**Wentworthville Northside West Clinic Extension (SSD-17899480)
Response to Submissions**

ATTACHMENT 1 – KEY ISSUES / FURTHER INFORMATION REQUIRED

1 DA - West Elevation - Lytton Park View  
Scale: 1 : 100

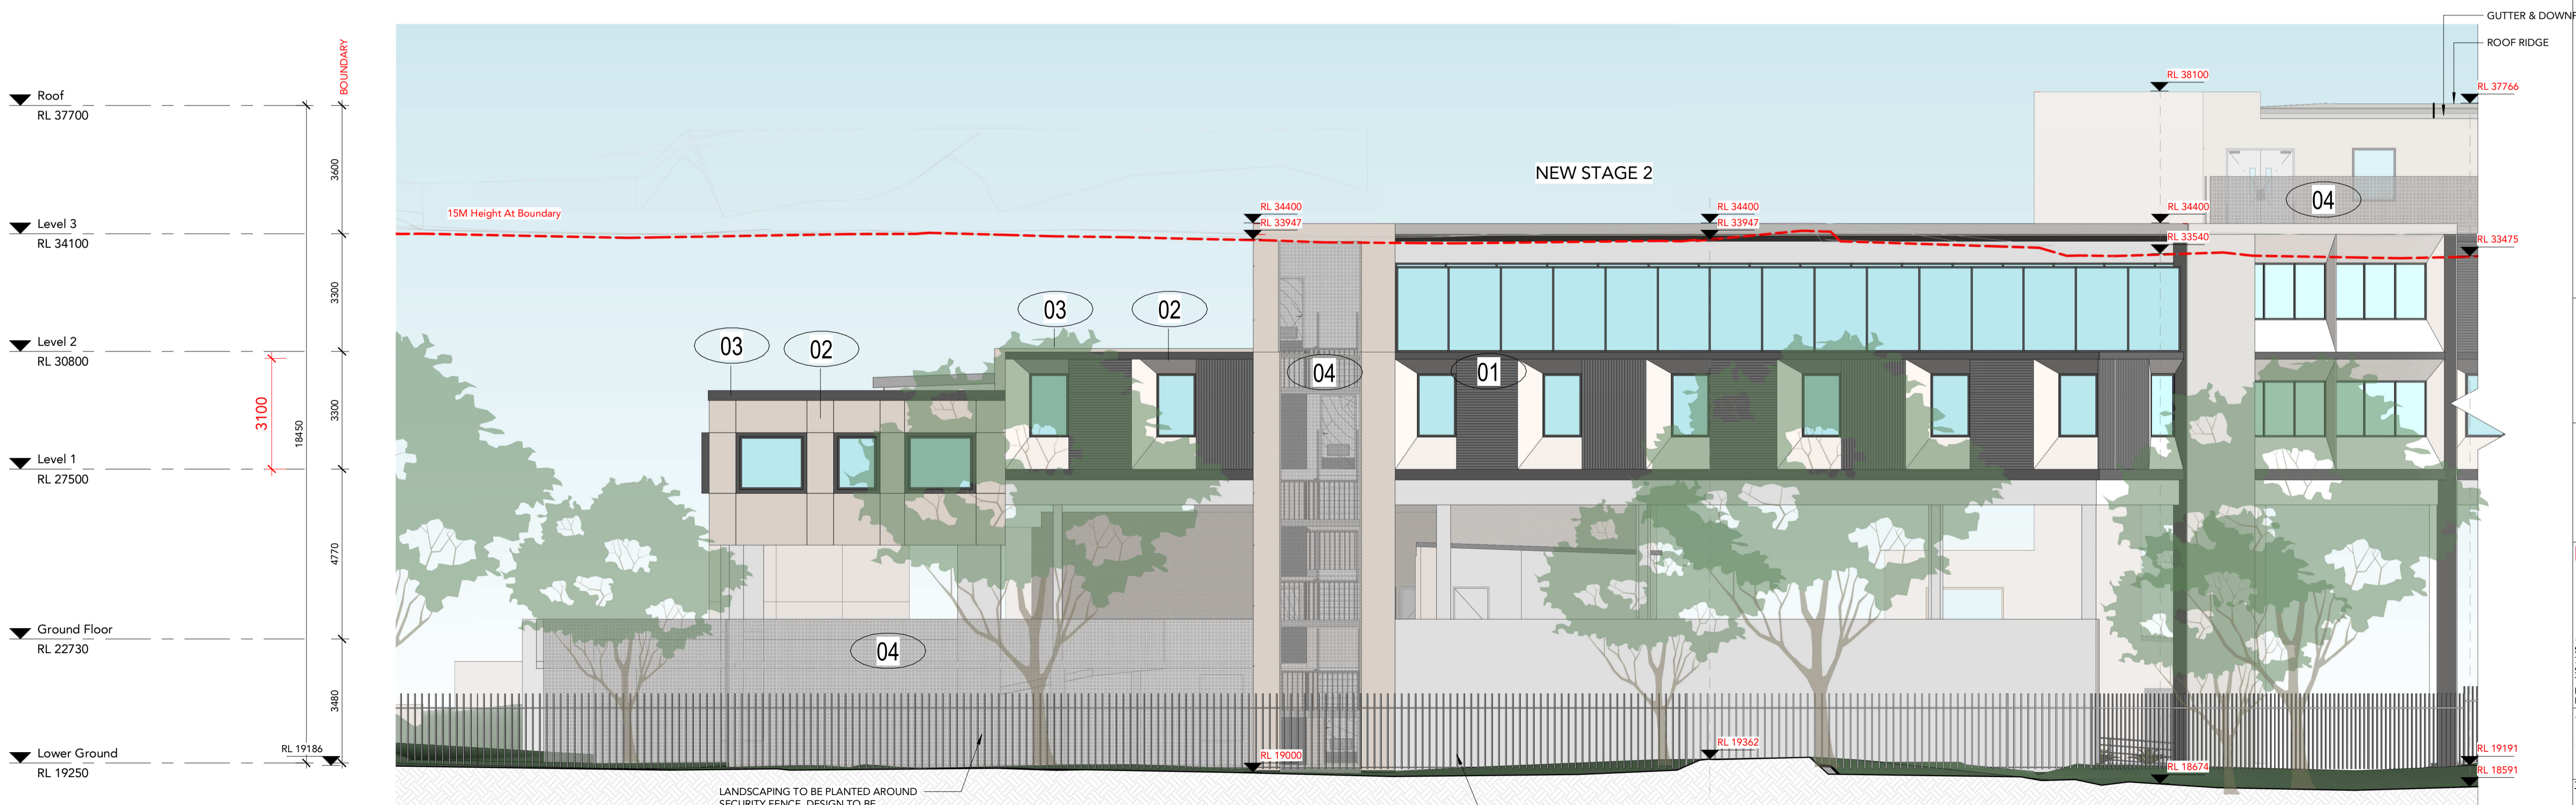
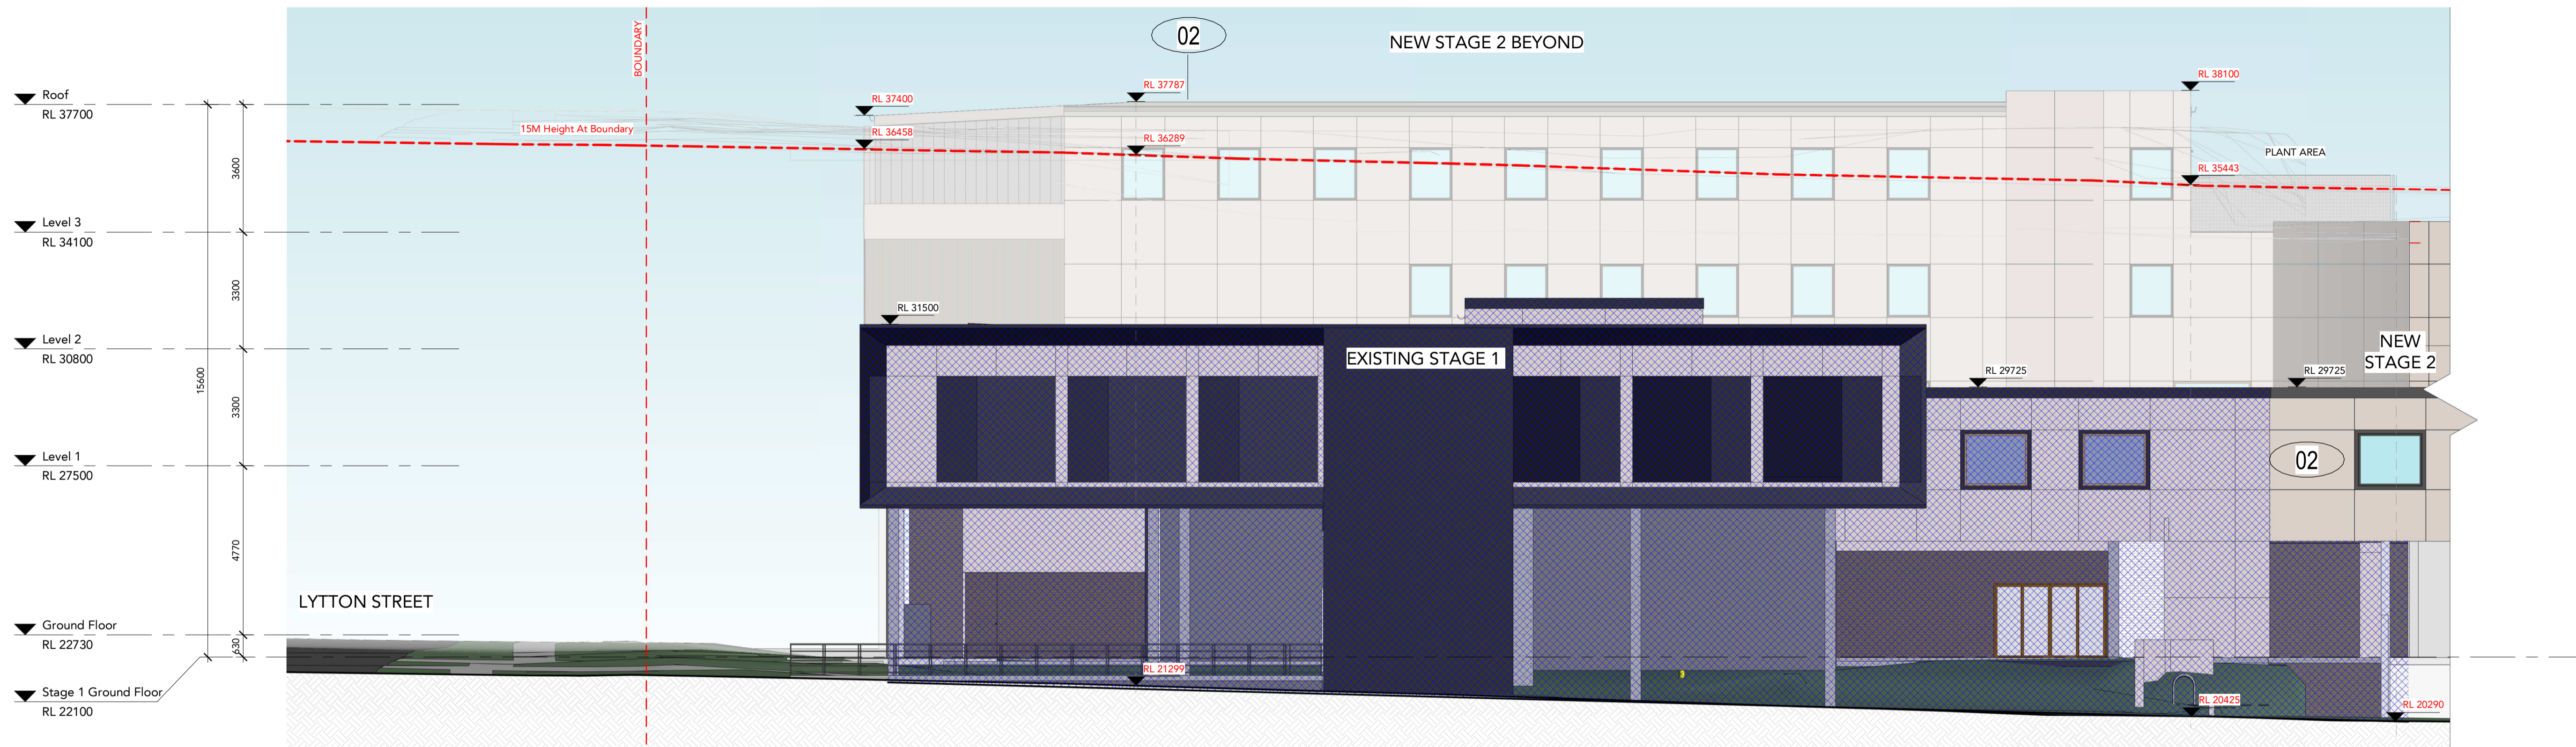
- the external façade alignment is inconsistent with Stage 1 and does not appear to be seamless.
5. Provide consideration of opening the western boundary ground level carpark to the landscaped areas through the removal of the screening.

**1 SECTION A-A SHADOW-WINTER SOLSTICE**  
Scale: 1 : 100

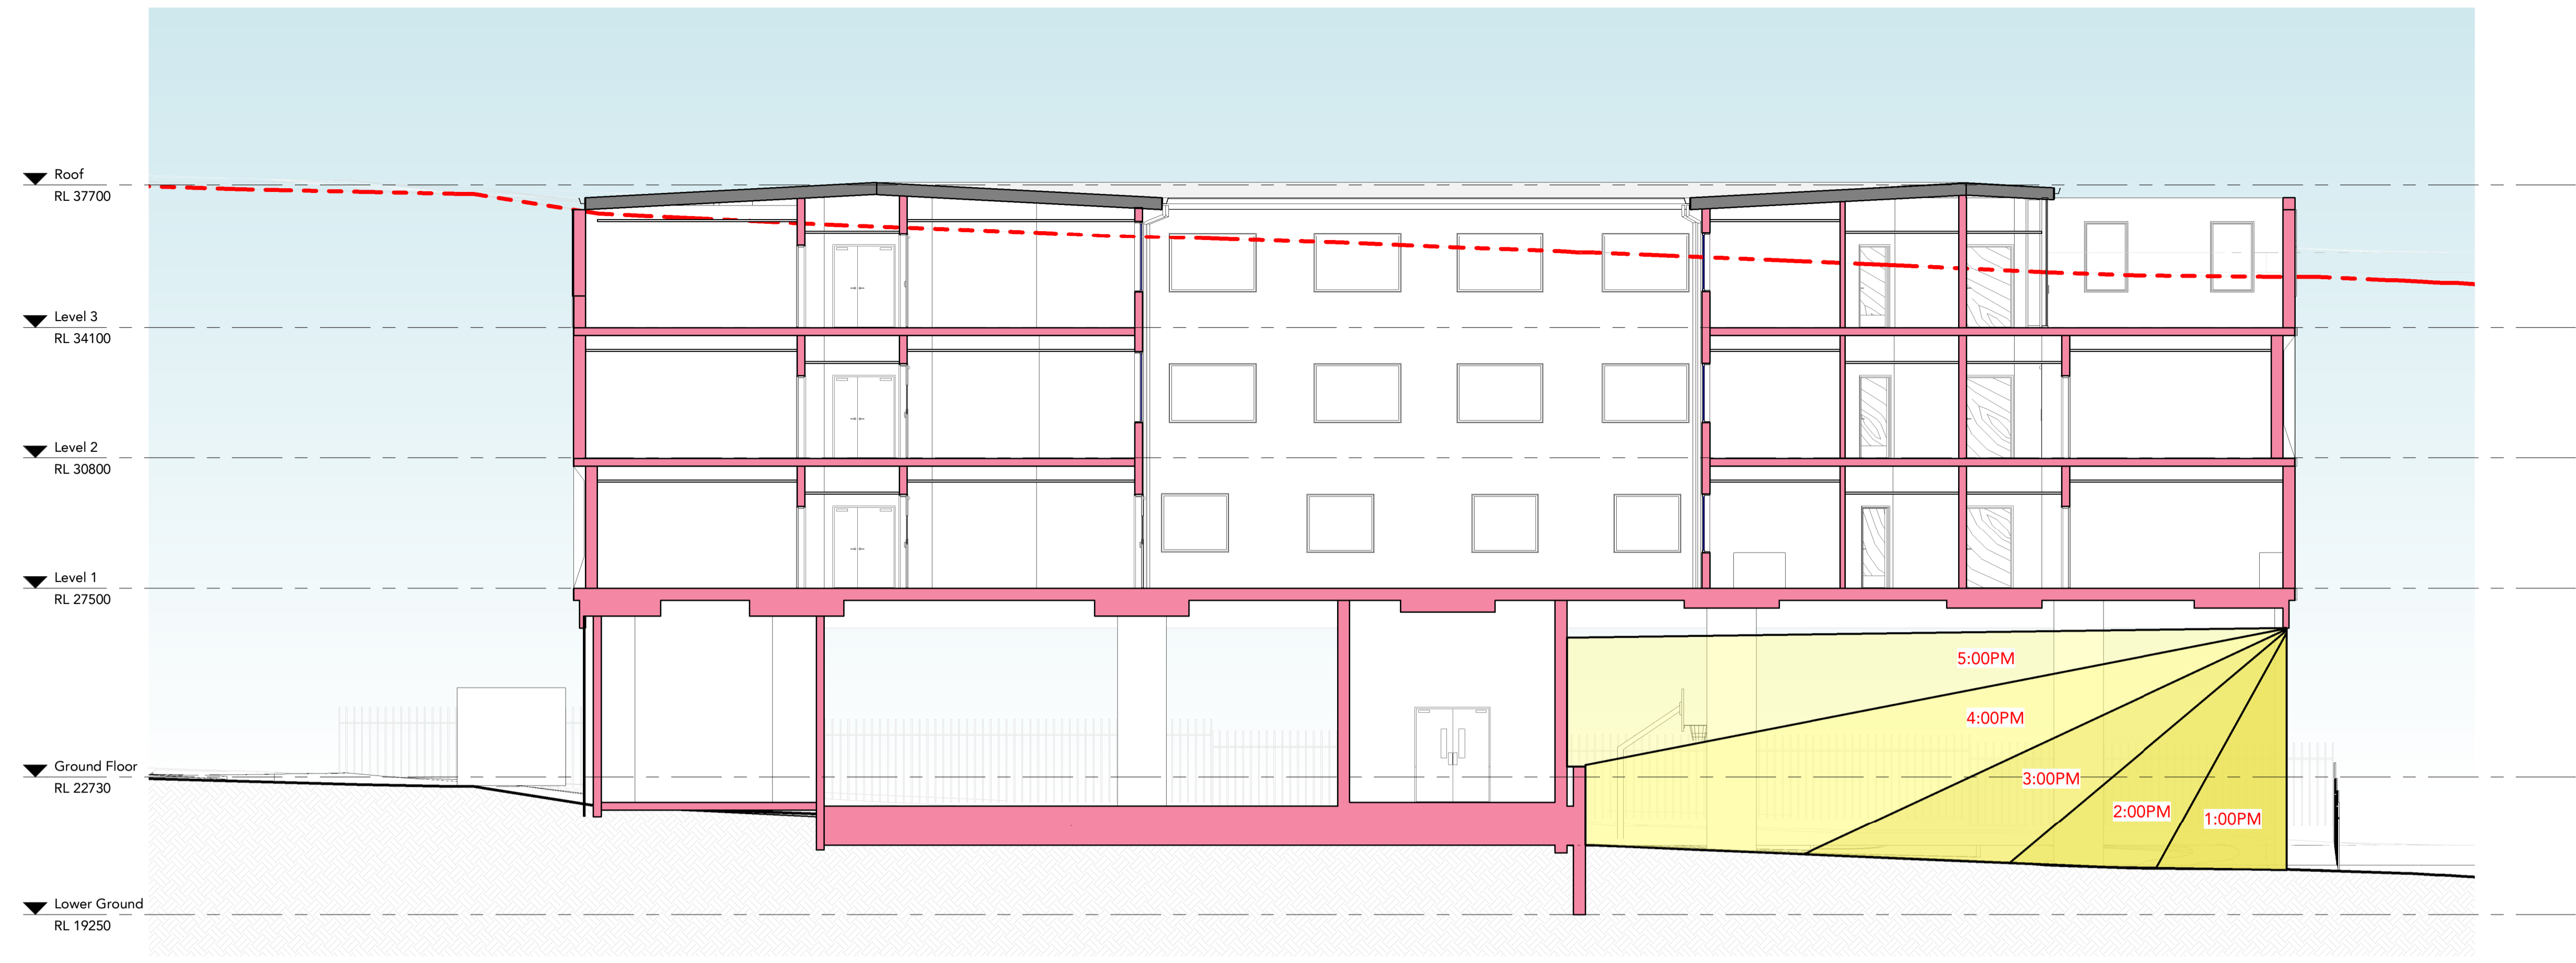
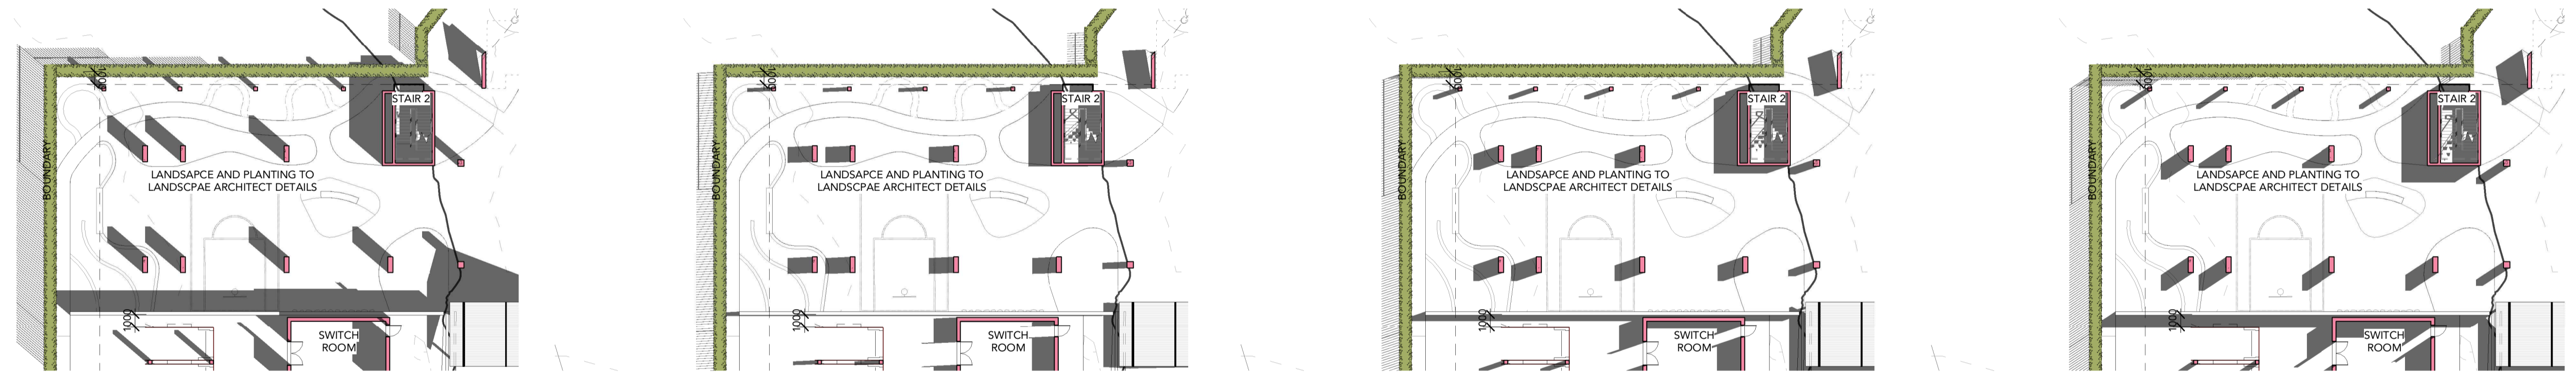
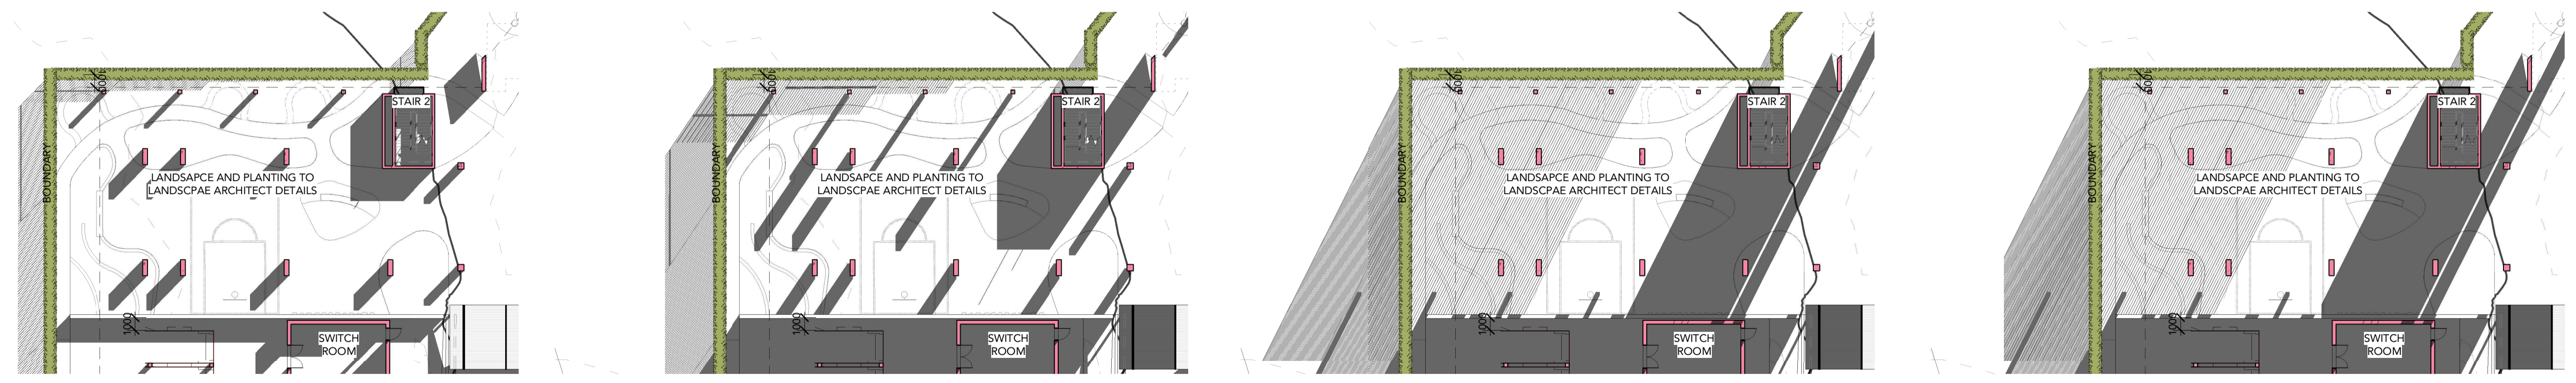
2. Demonstrate how the undercroft landscaped area will receive adequate solar access as well as appropriate passive surveillance considering there are limited active use rooms with windows on the ground floor facing this part of the development.
